ADC PARKS & GREENSPACE ARBORICULTURE CONSULTATION

PLANNING APPLICATION: AW/286/12/T

ADDRESS: Runnymede 221 Aldwick Road Aldwick PO21 3QG

BRIEF DESCRIPTION: Trimming of 1 No London Plane tree by 1m-1.6m all around

Proposed shaping of tree by trimming and then maintaining this shape

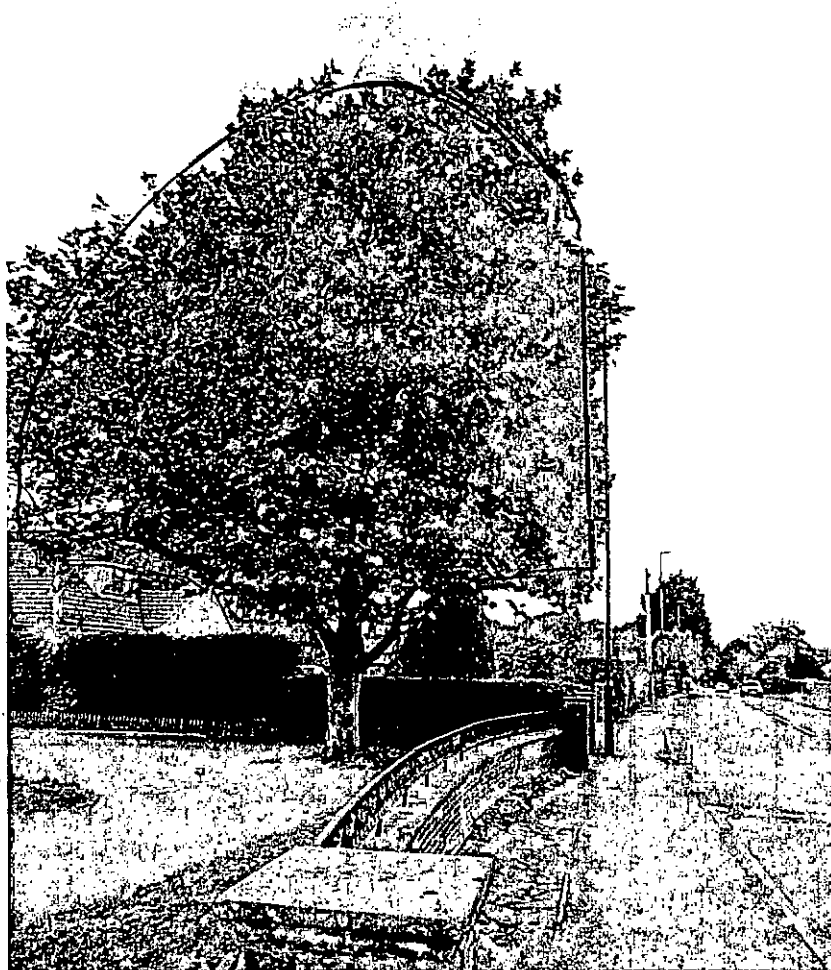
I have inspected the Plane tree and accept the applicants request for tree work. The work must be carried out in accordance with the dimensions to be removed in the two photographs attached which form part of the application and to the high pruning standards of BS3998 (2010).
